A1 in Northumberland: Morpeth to Ellingham

Scheme Number: TR010059

7.13 Applicant's Response to Deadline 2 Submissions

Applicant's Response to Deadline 2 Submissions

Corrected Figure 32 of the Case for the Scheme

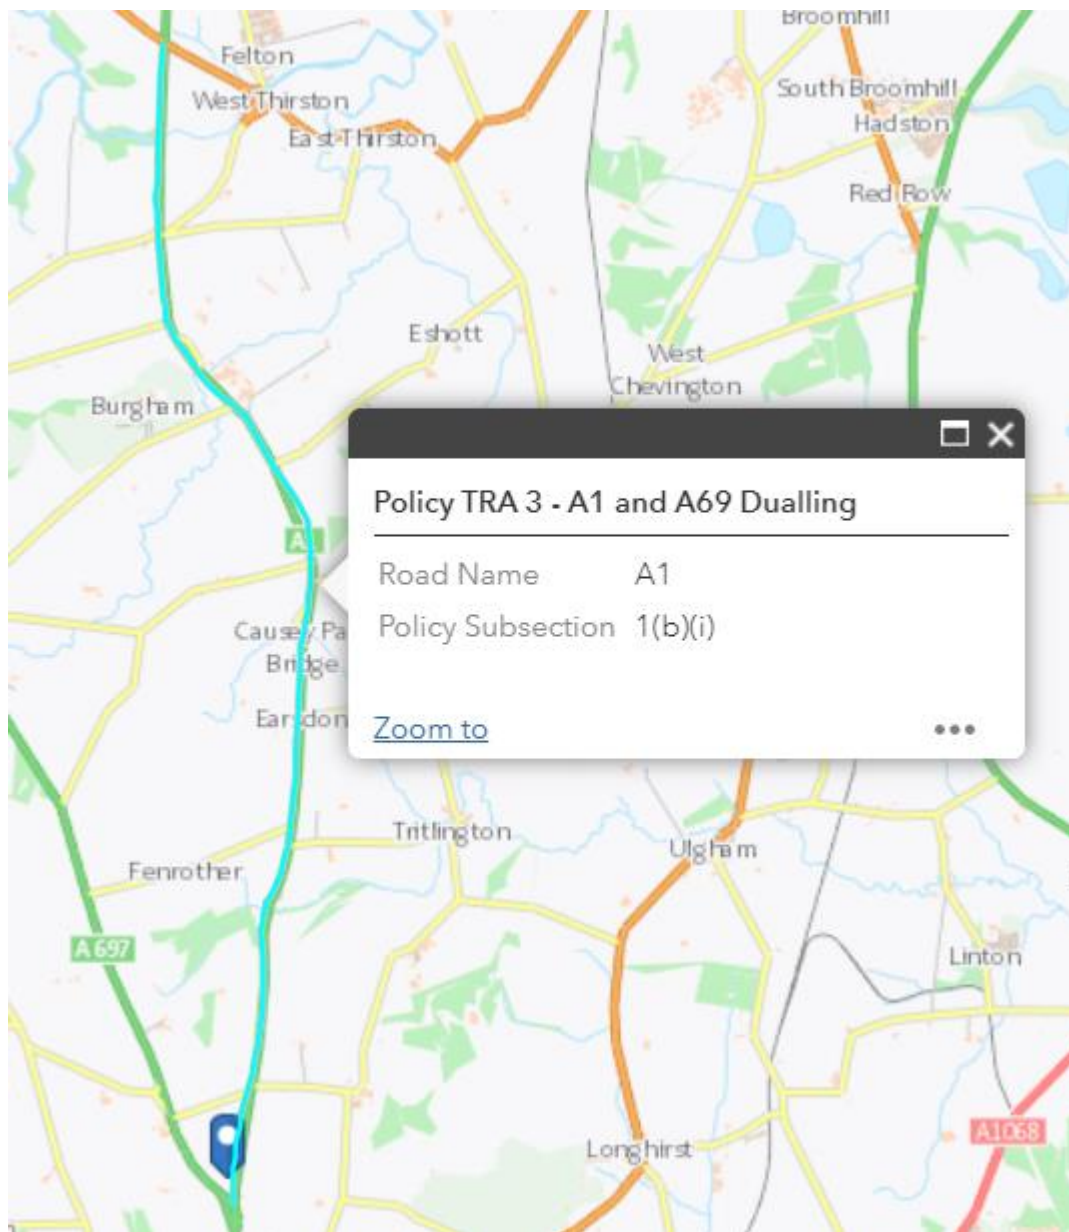
Ref. No.	Response:	Applicant's Response:
GEN.6 - Figure 32 WQ GEN.1.28		
REP1-064 Applicant's Response to Relevant Representations	1.2 Local Authorities	
	Table 1-1 - Northumberland County Council – RR-001 1.1.2 The response here sets out a comprehensive explanation of the community benefits that will accrue and it can be accepted that these will contribute positively to the planning balance. We have noted elsewhere comments in certain responses, from communities or individuals, to the effect that the layouts will reduce accessibility and lengthen journeys but can accept that the optimal solution will be arrived at – e.g. in terms of bus stop locations and how communities access the A1 via the new junctions – as a result of ongoing discussions and taking all other factors into account.	1. The Applicant notes that NCC considers that the proposed road layouts achieve the optimal solution in terms of accessibility and journey times.

**Trees to be Removed and Replaced at Coronation Avenue  
WQ LV.1.8**

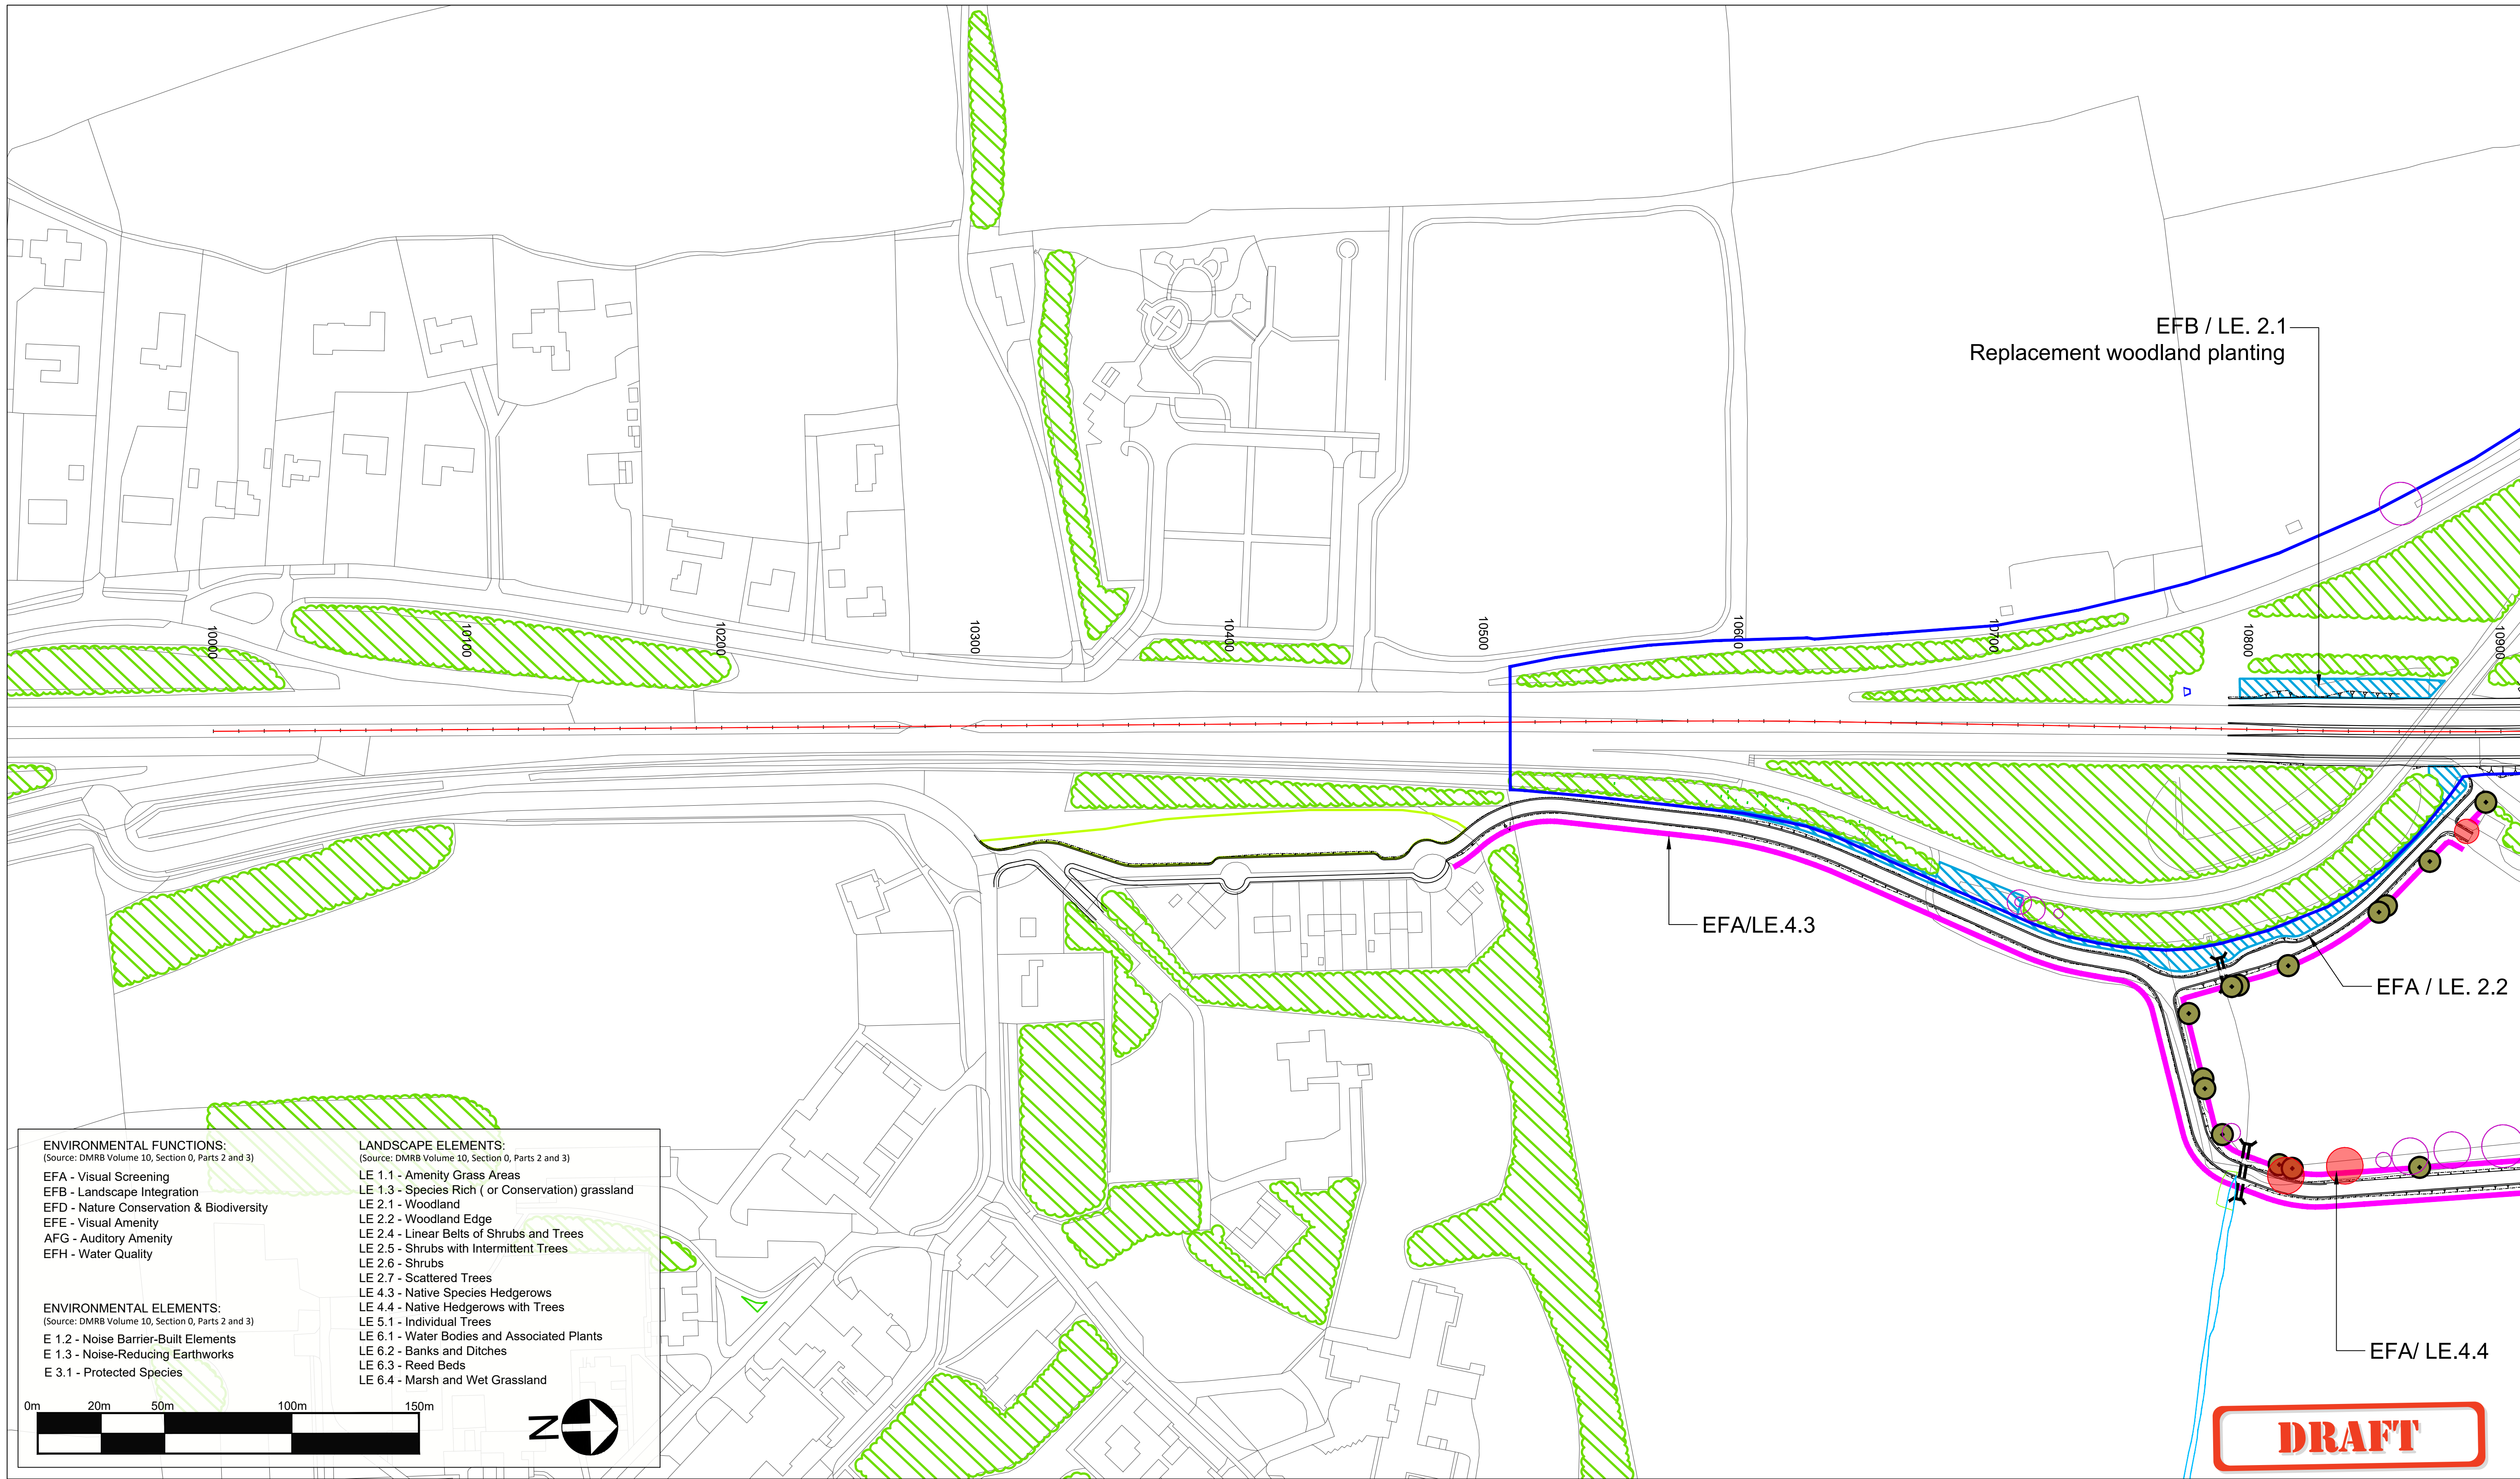
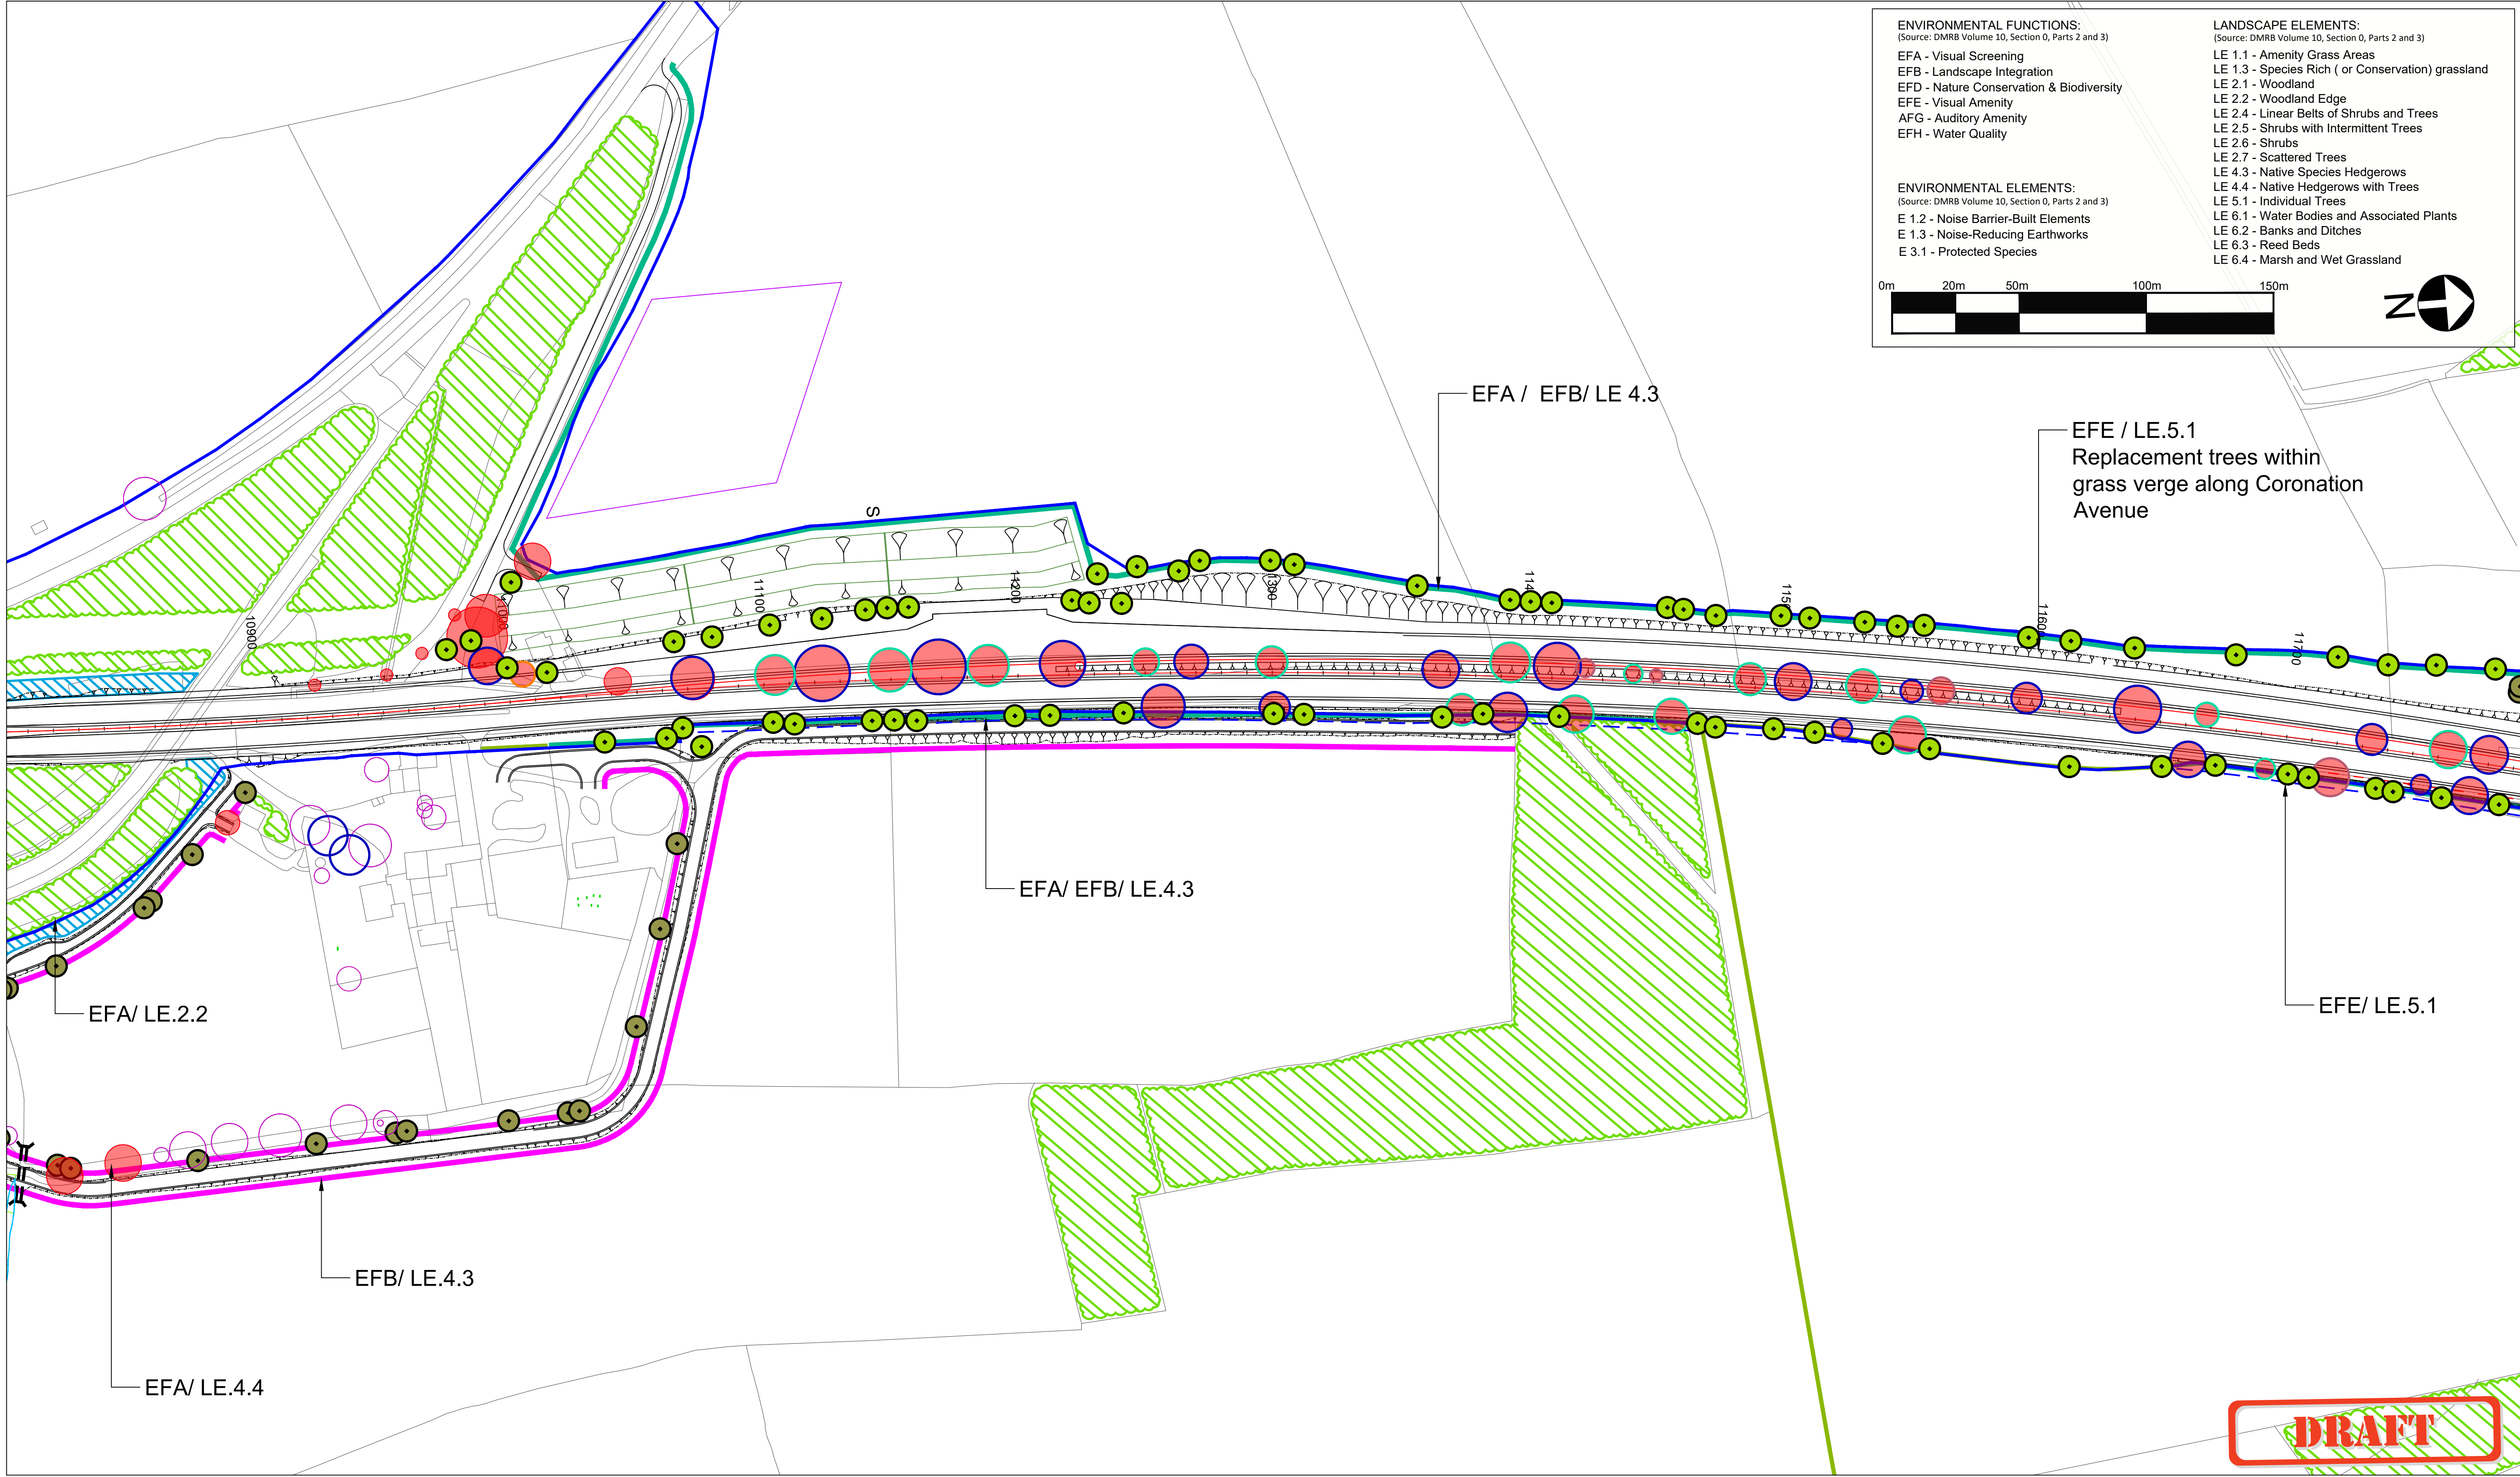
<p>Appendix LV.2 REP1-044</p>	<p>As previously reviewed and agreed.</p>	<p>1. It is noted that NCC are in agreement with Appendix LV.2 [REP1-044] which sets out the proposed approach to replacing trees at Coronation Avenue.</p>
